Environmental Health Consultation Response	Officer	Alan Taylor
---	----------------	--------------------

Detail: Planning request 3/2017/0876

Address:	Higher Trapp House Simonstone BB12 7QW		
Application Ref:	37639	Case Officer:	Adam Birkett
Response Ref:	t/ENV/01	Issue Date:	24 October 2017

FLOOR PLAN

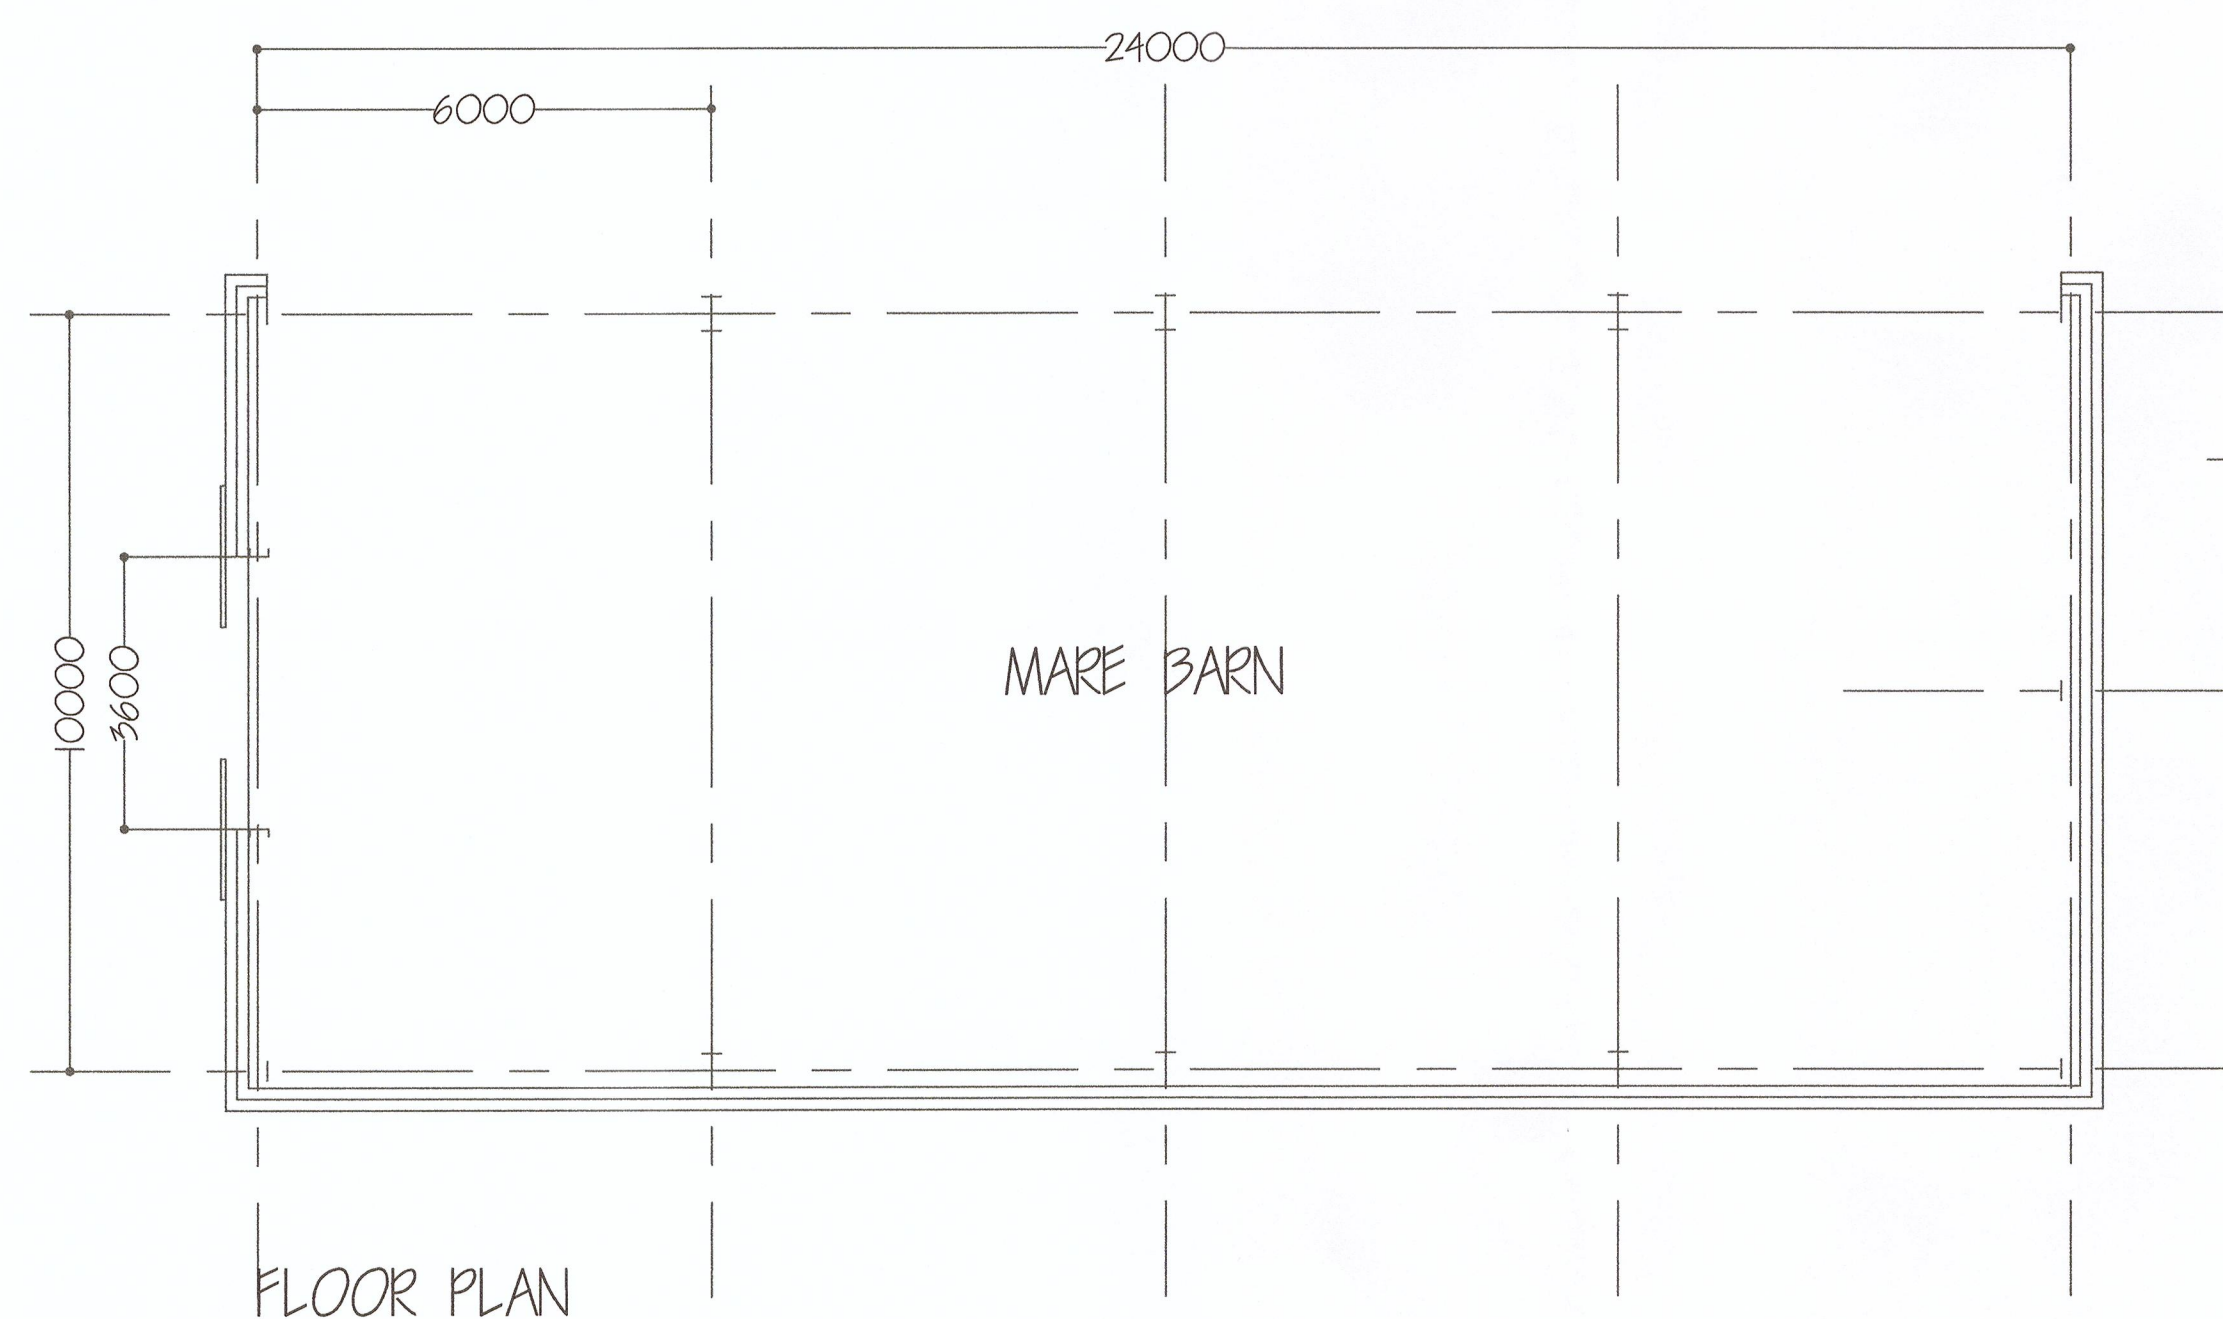
1.1 The planning application indicates a new building of a barn house for mares. There is no indication of how many mares are to be housed in the new build barn? There is little information to make general comments regarding this application. Will the new stables be used for anything else other than the housing of mares?

2.1 The size of the proposed barn would indicate there to be a number of mares to be stabled on site in the new building, how many?

2.2 The increased levels of horse manure will require increased storage capacity. There is no mention of these increased levels for storage or method of disposed indicated in the application?

- The application needs to indicate the number of mares to be stabled.
- The application should provide further information on where the increased levels of manure are to be stored and how these will be finally disposed of?
